DOC22/134098

### **EPA Advice on Submissions Report**

I refer to the request for advice from Public Authority Consultation (PAE-2880), requesting the review by the Environment Protection Authority (EPA) of the Submissions Report for the proposed expansion of operations (Application SSD-8804) at the existing Howlong Sand and Gravel Quarry at Howlong.

## Attachment A

2.2.2 Noise contour map of quarry during Stage 2

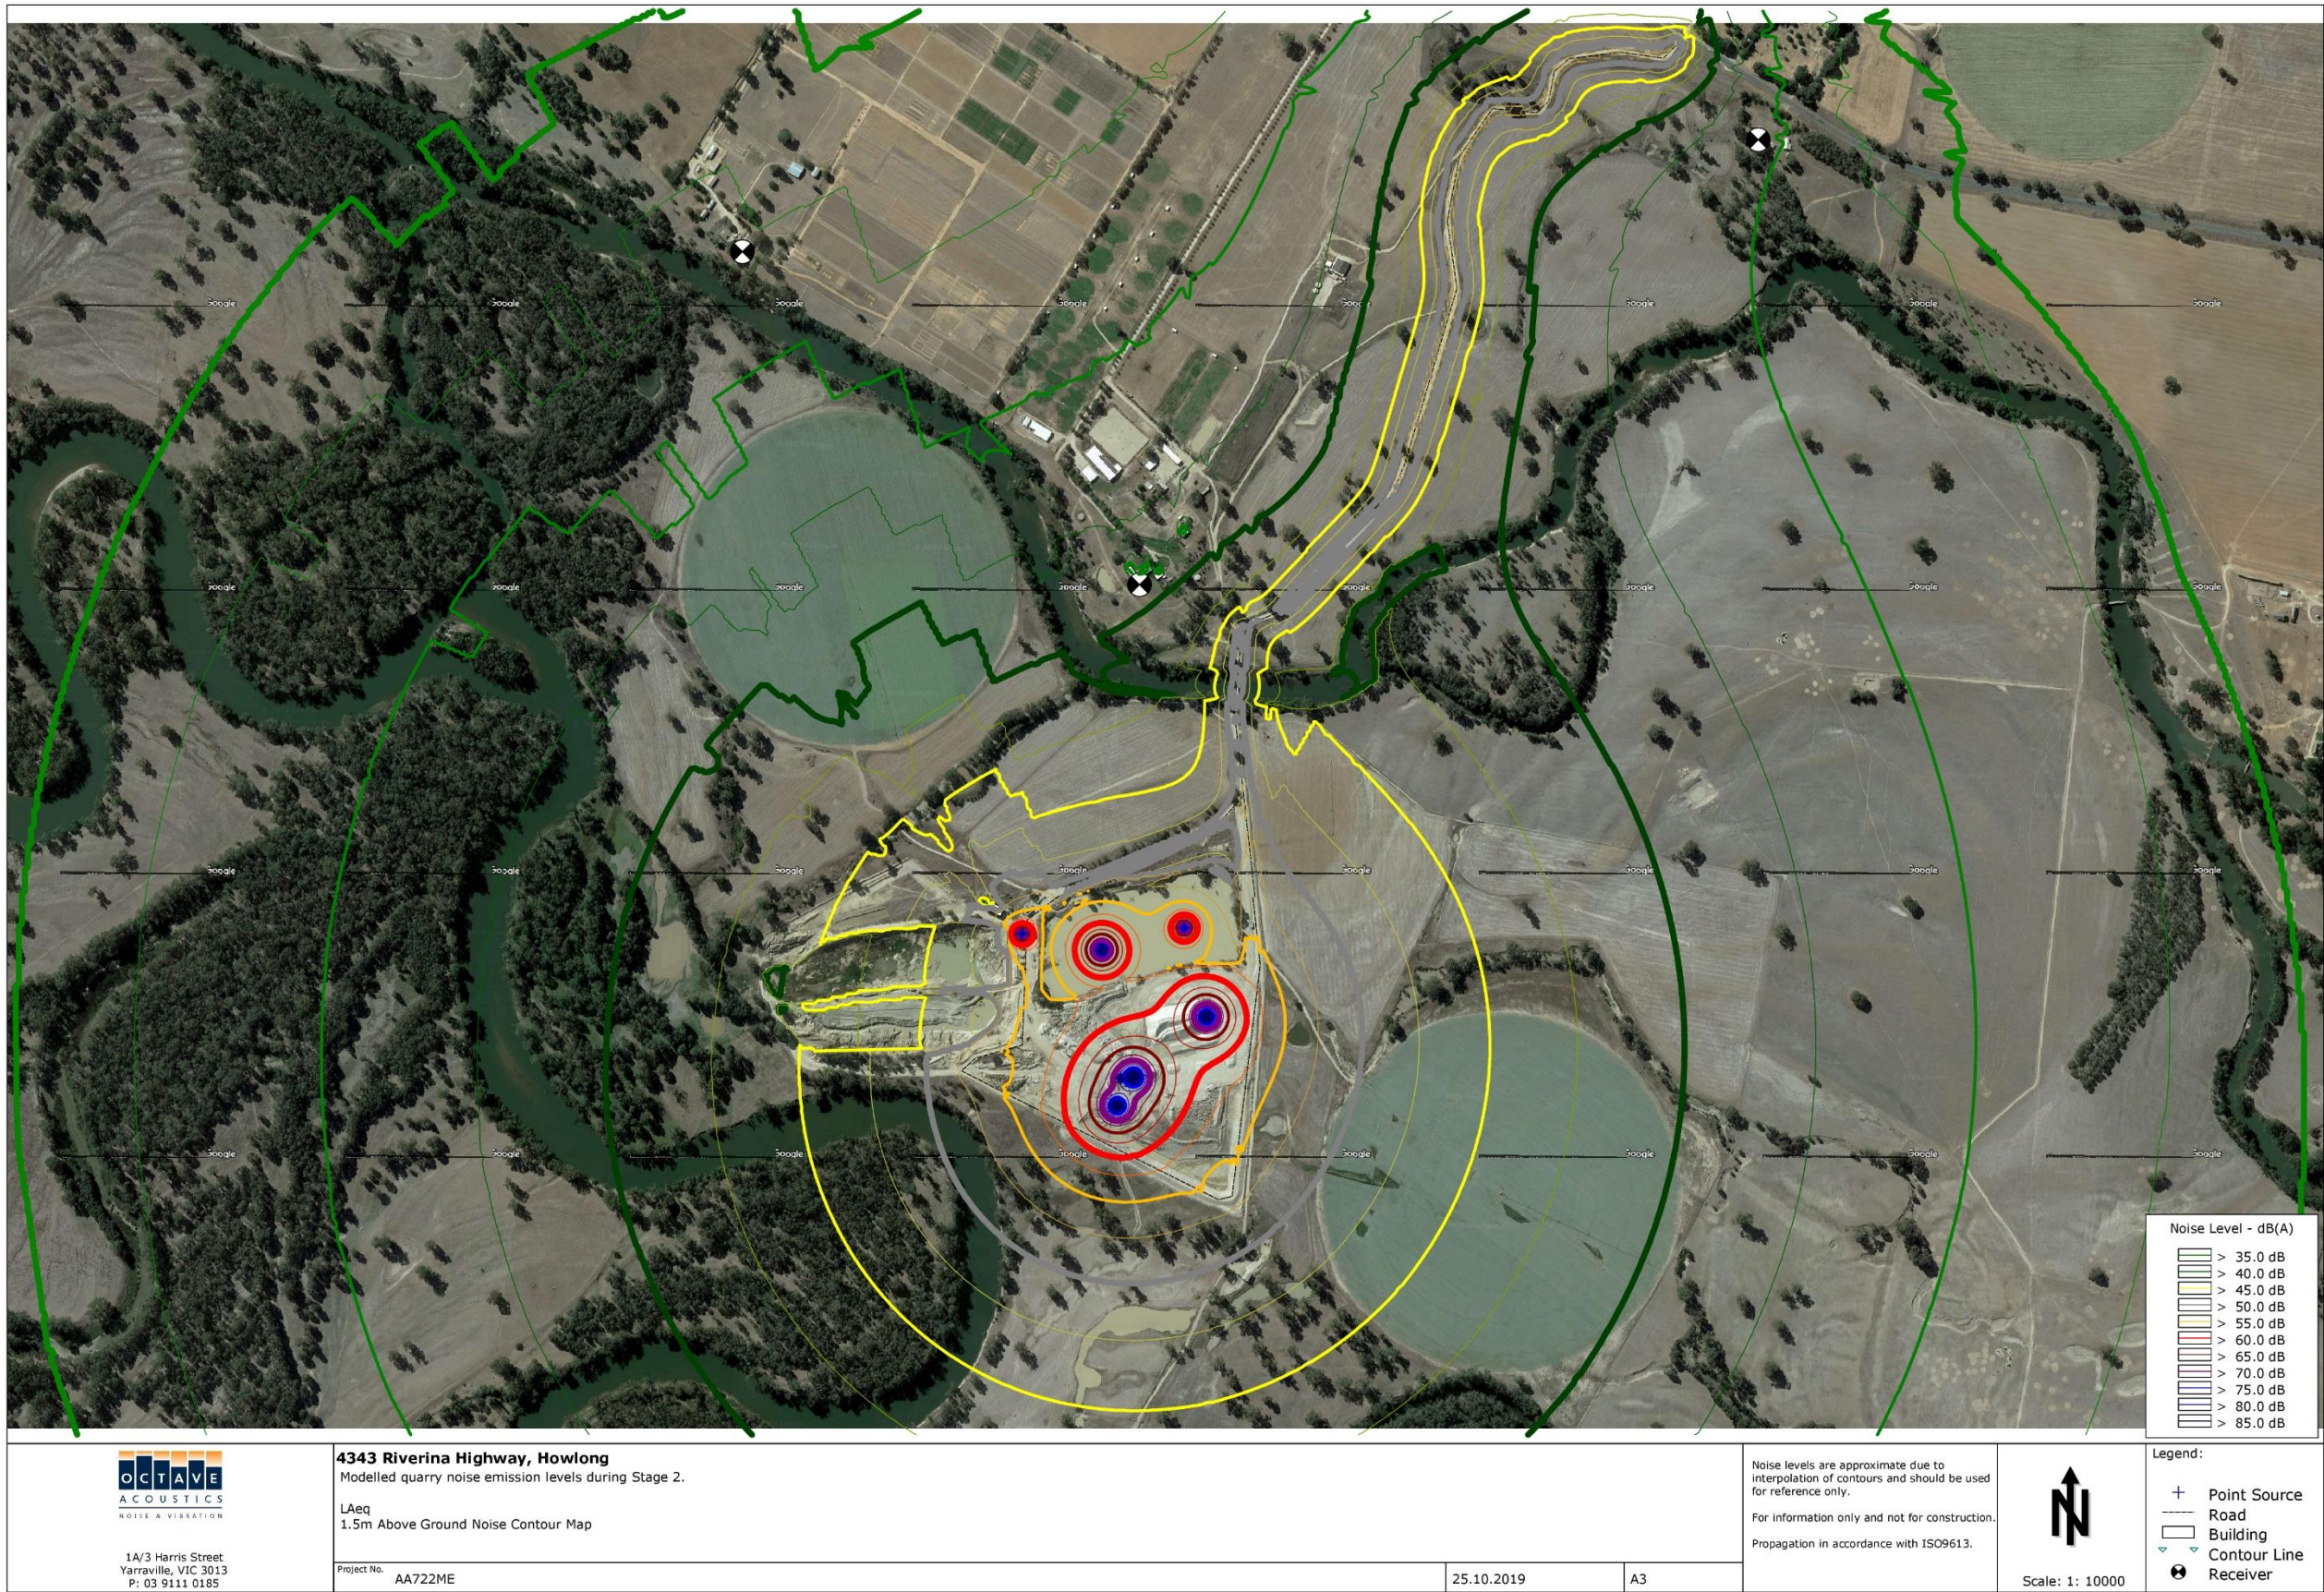
- L2.1** Noise generated at the premises must not exceed the noise limits at the times and locations in the table below. The locations referred to in the table below are indicated by Figure 2.2.2 in Noise Modelling Assessment for the Howlong Sand and Gravel Expansion Project, by Octave Acoustics, dated November 2019.

Location	Noise Limits in dB(A)	
	Day	Evening
	L <sub>Aeq</sub> (15 minute)	L <sub>Aeq</sub> (15 minute)
4343 Riverina Highway, Howlong (Lot 1, DP 798291)	40	38
Camp Nelson Scout Camp, 4271 Riverina Highway, Howlong (Lot 7009, DP 1028263)	45	40
Any other residential receiver	40	35
